Timberline Storage Yard Comment Response Letter

November 20, 2019

RE: Sterling Ranch Comments - SF-17-025 - Homestead at Sterling Ranch Filing No. 1.

Enclosed are the response to comments provided by El Paso County Development Services Department on the Timberline Storage Yard PPR-19-042, Second Submittal

## OVERALL GRADING AND EROSION CONTROL PLAN

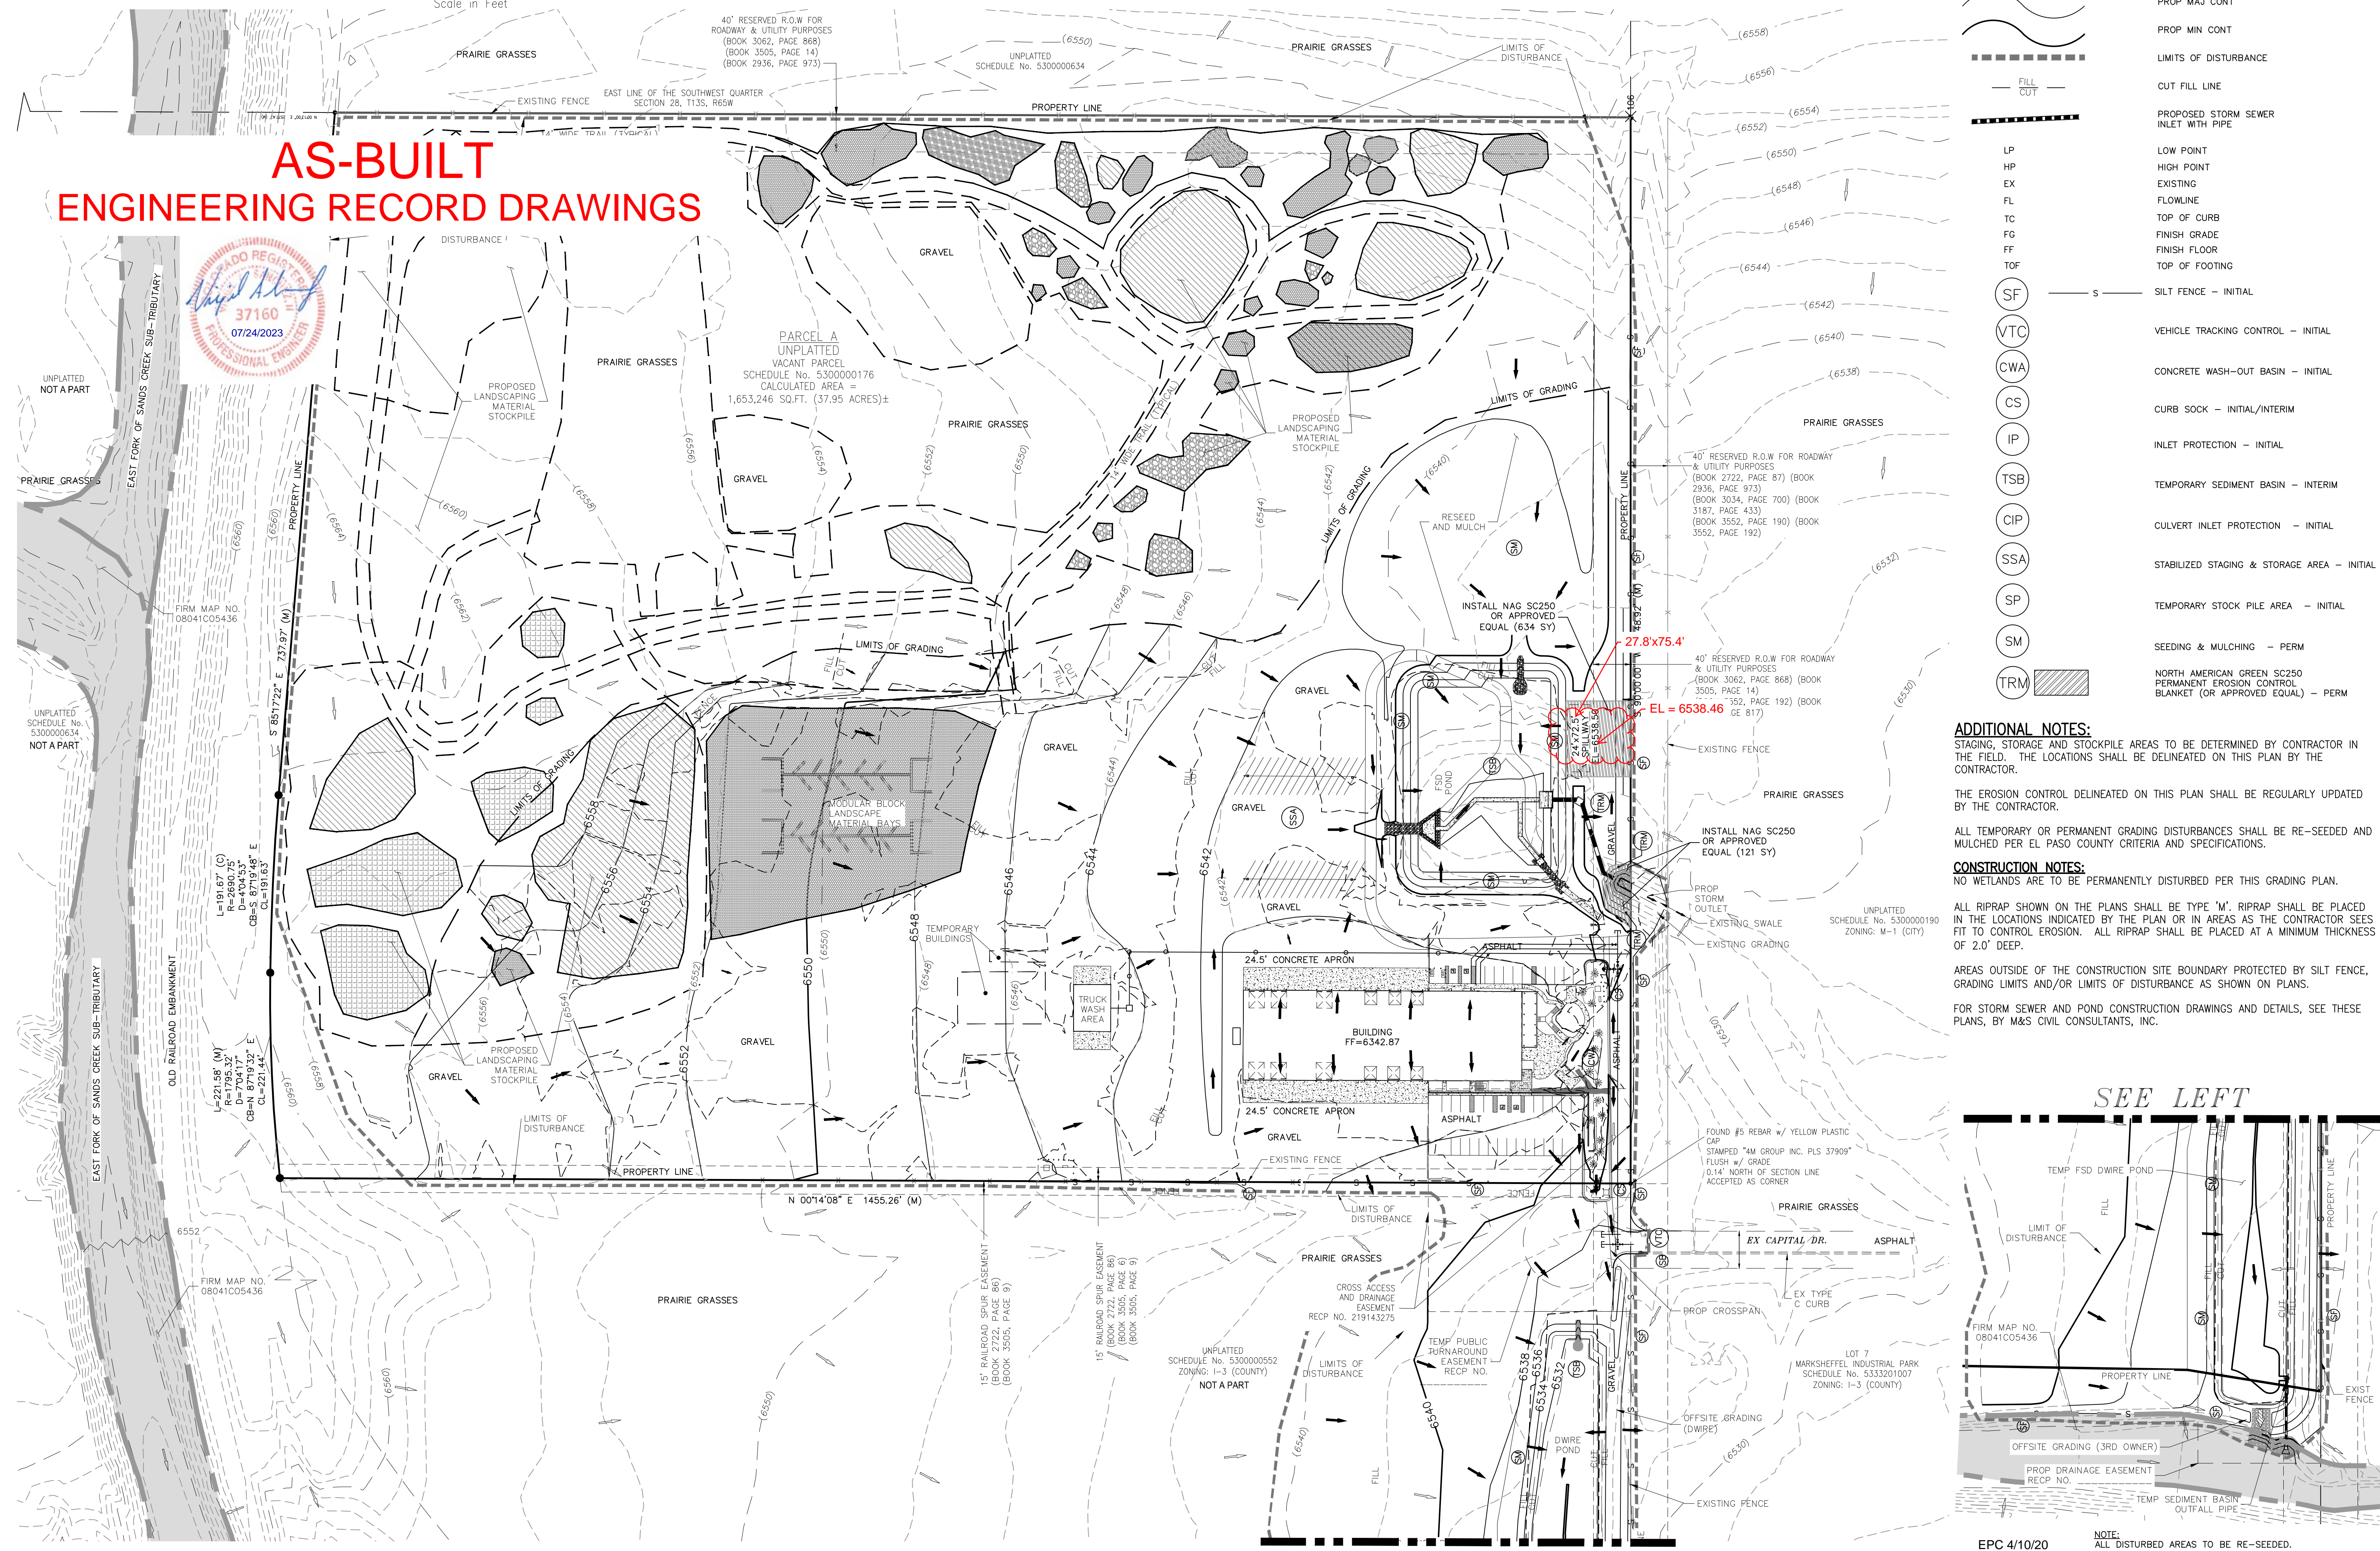
1. See Site Development Plan redlines. **Noted**
2. Remove "future" improvements from the site development plan. These can be shown in the drainage plans but are not being approved.
The future improvements have been removed from the plans.
3. Provide the plan of the entire site. Label all proposed cover surfaces (gravel/concrete/asphalt/natural vegetation, etc.). In the future if impervious surfaces are placed where more pervious surfaces or natural ground is shown, an amended site development plan will be required prior to that occurring.
The entire site has been added to the drawings on Sheet 2.

**FULL SPECTRUM DETENTION POND 1 SITE PLAN**

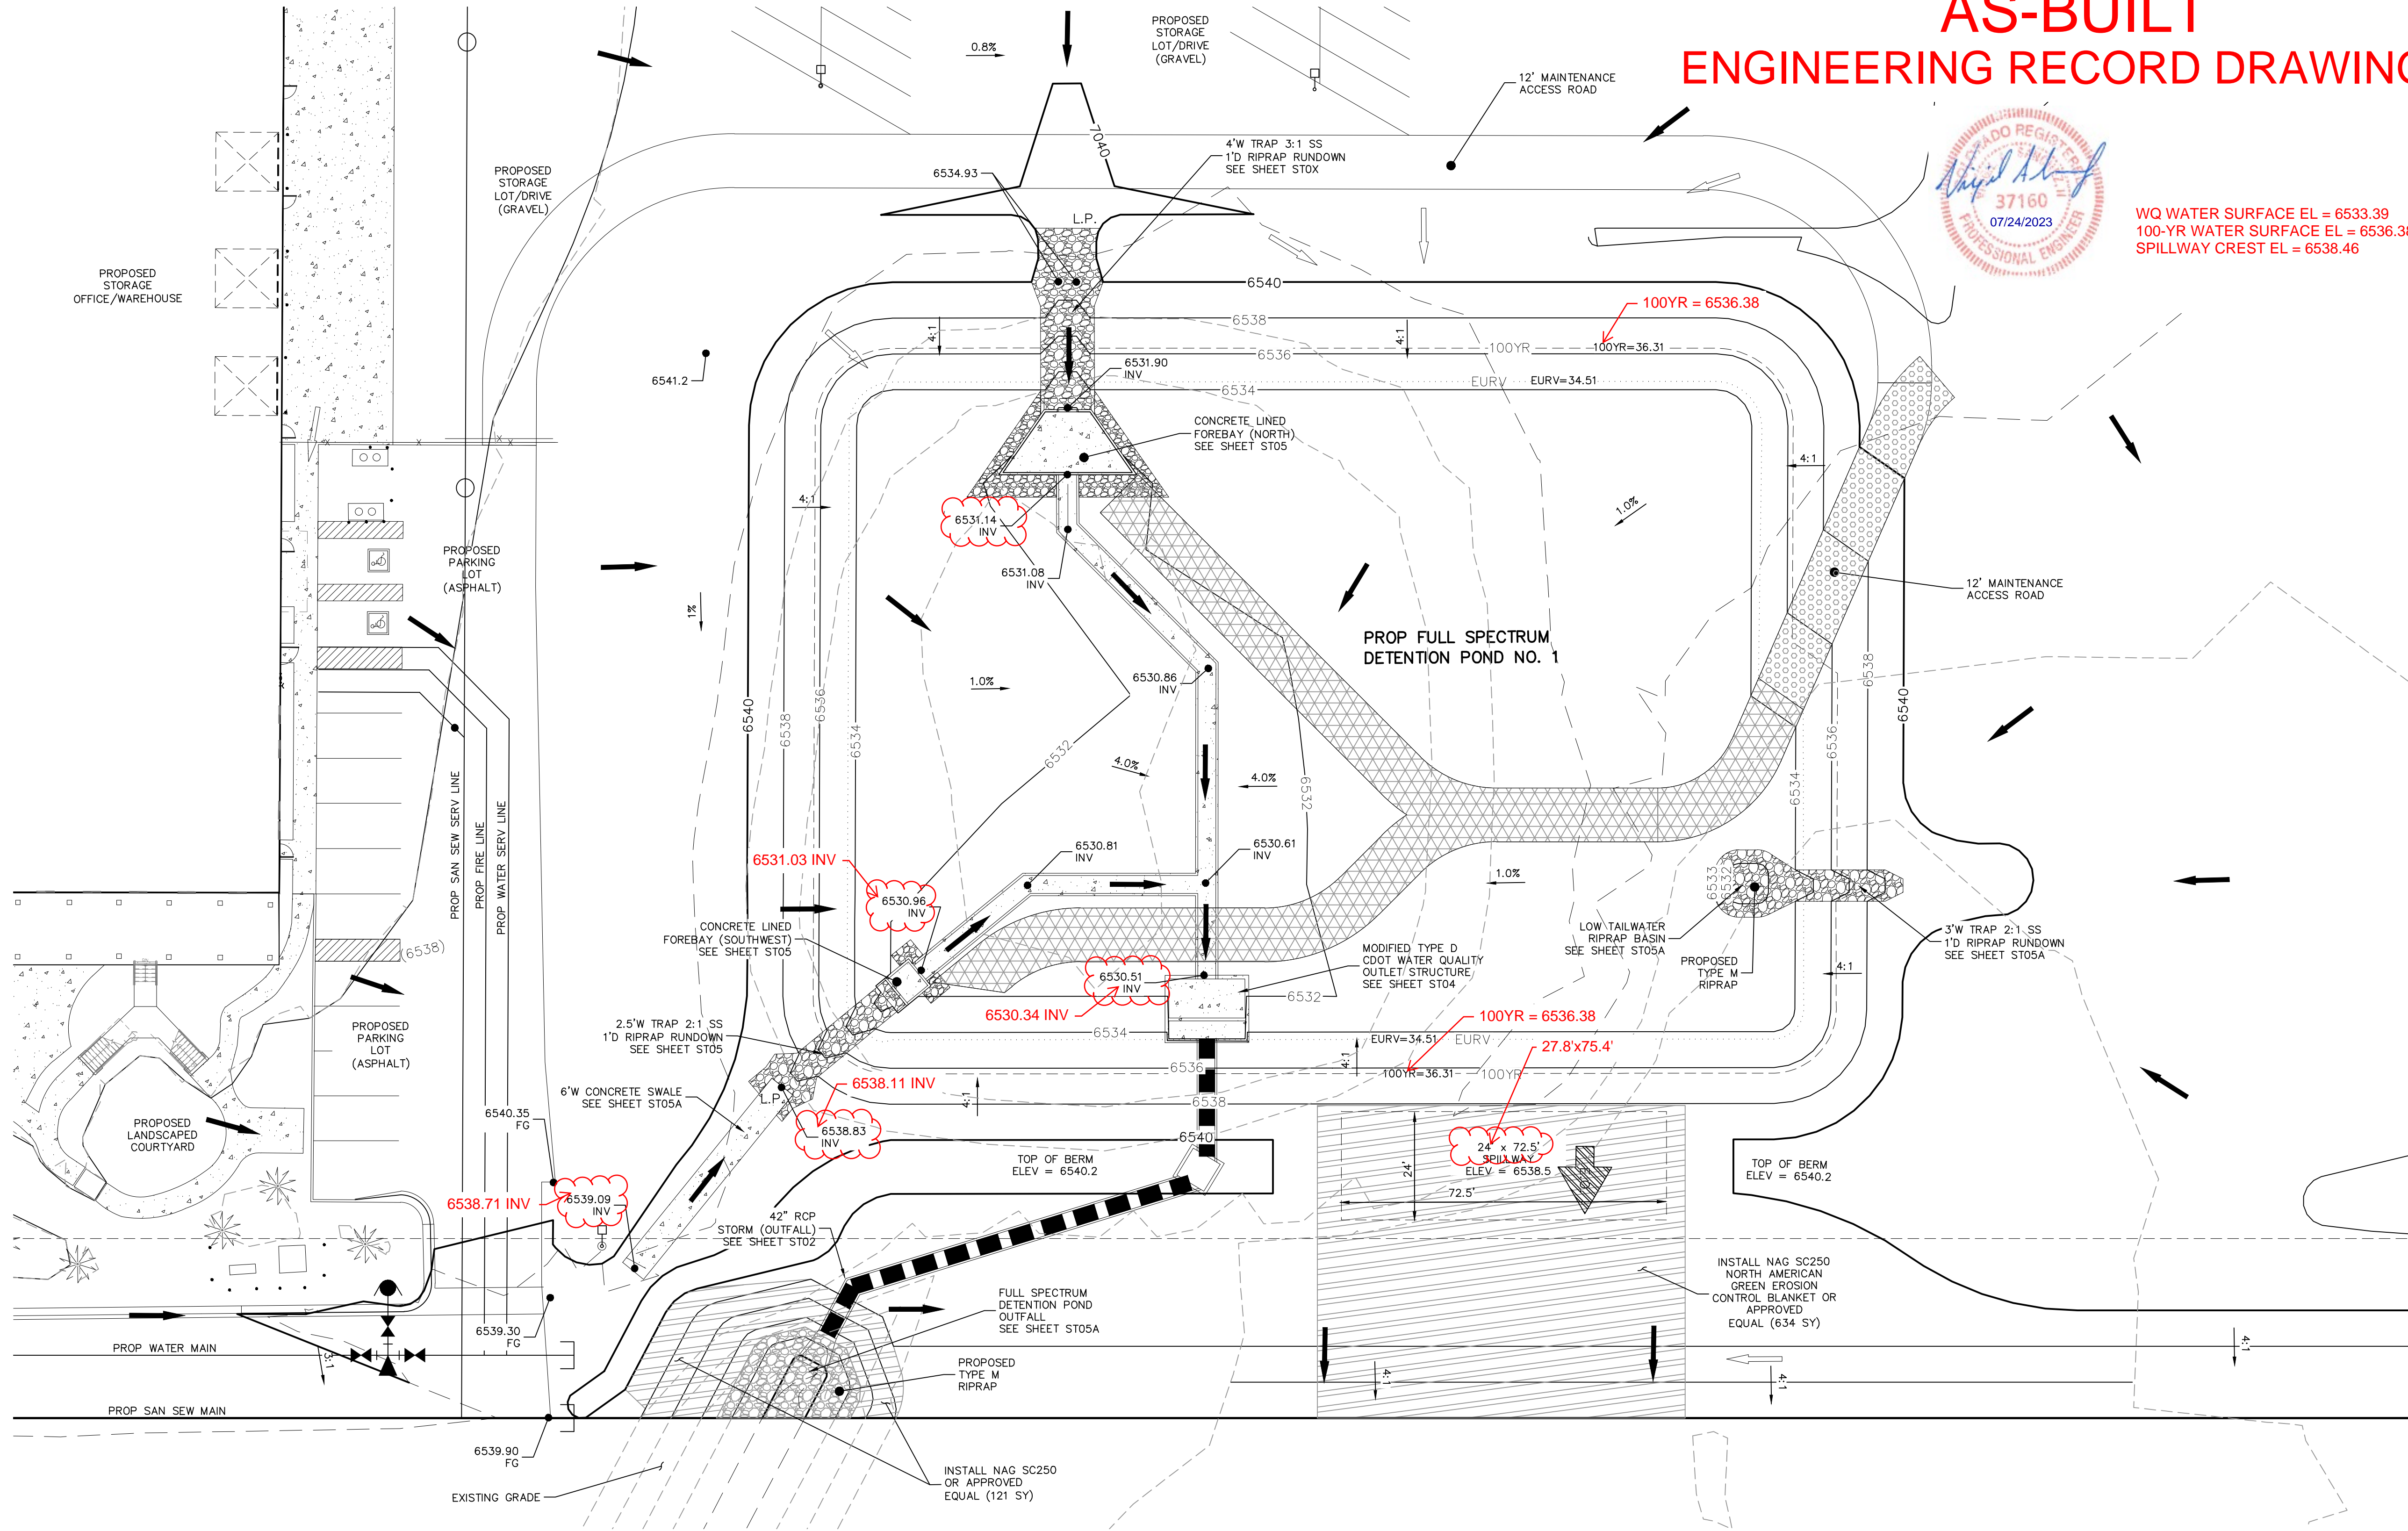
Comment regarding the UD-Detention Basin Outlet Structure Design sheet Ratio of Peak Outflow to Predevelopment Q in excess in 10-year, 25-year and 50-year in excess of acceptable levels. Attempts were made to reduce these outputs to acceptable levels.

Trial 1: The restrictor plate which at present is at a 27.15" above the pipe invert to release the historic 71.5 cfs would have to be choked down to 7" above the pipe invert (historic flow at 7" release 79.4 cfs through the spillway), in order to achieve the desired levels. The structure control flow would also overtop the spillway prior to the 50 year mark.

Trial 2: The inlet dimensions are at 4' x 17' to release historic flow of 71.5 cfs, would have to be down sized to a 5' x 3' inlet which would achieve the desired levels but the max velocity through the grate are in unacceptable levels. The inlet would restrict the 100 year historic to 68.4 cfs. The structure control flow would also overtop the spillway prior to the 100 year mark.

In our opinion both these solutions are an unacceptable engineering practice. Please note the City of Colorado Springs, knowing the difficulty of balancing the above noted UD-Detention sheet, have accepted the above calculations as long as the WQCV, EURV, 5 year and 100 year are meet acceptable levels. See attached Trial (s) spreadsheet.
